# Rezoning Transportation Analysis

Petition Number: 2021-079

## Revision Log:

Date	Description
08-02-2021	First Review (WB)

DRAWING NO.: **RZ-01**

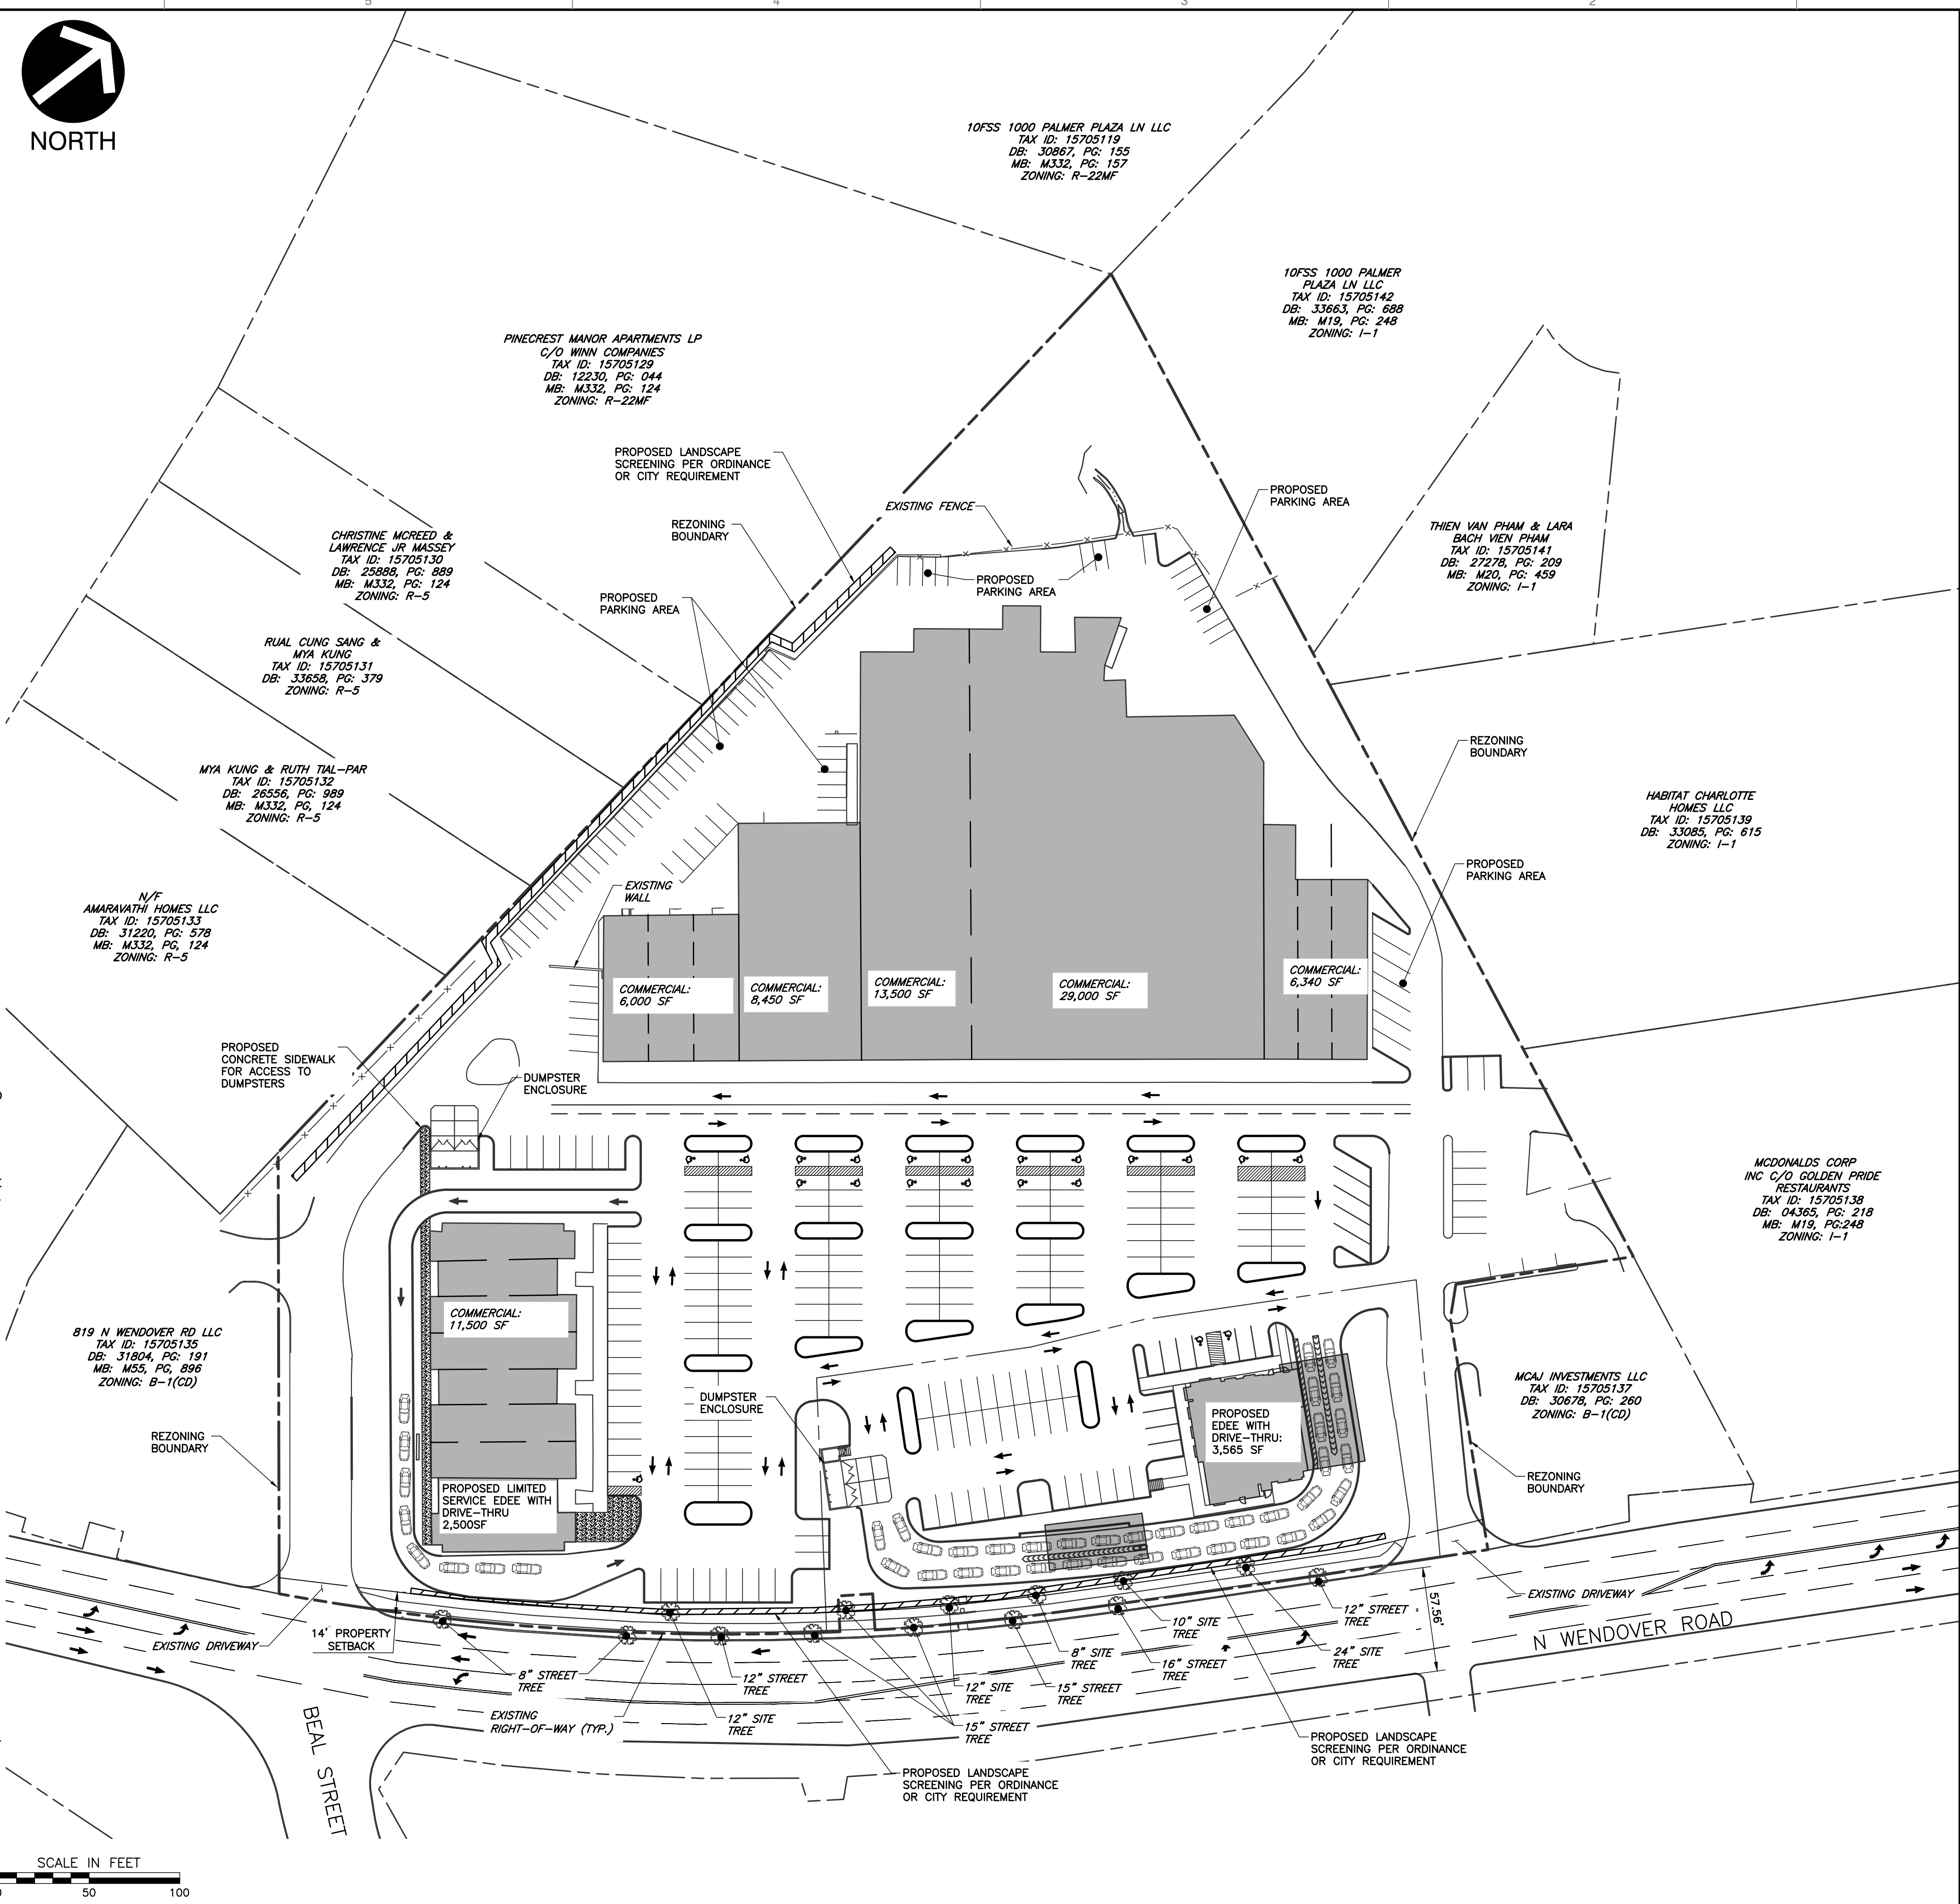
1. **Curblines:** The proposed zoning district has a setback measured from back of the existing or proposed future curblines.
  - a. **North Wendover Road:** The future location of curb and gutter is in its existing location.

Label and dimension the curb and gutter from the centerline for each road on the site plan.

3. Revise site plan and conditional note(s) to commit to dedicate 50' right-of-way from the road centerline. The site plan shall label and dimension the right-of-way from the road centerline.

4. Site plan and conditional note(s) revisions are needed to commit to installing a 12' multi-use path with an 8' planting strip to meet the Charlotte BIKES Policy.
5. Revise site plan to adequately depict the existing Pedestrian Hybrid Beacon (PHB) to remain on Wendover Road.

- 6. Revise site plan and conditional note(s) to commit to provide convenient pedestrian access from the PHB into the site without crossing the drive thru.

*Approximate location of Proposed Pedestrian Access*

7. Add a site plan note specifying dedication and fee simple conveyance of all rights-of-way to the City before the site's first building certificate of occupancy is issued is needed.
8. Add a site plan note specifying that all transportation improvements will be approved and constructed before the site's first building certificate of occupancy is issued. The petitioner may phase transportation improvements if said improvements and phasing are explicitly described in site plan notes.
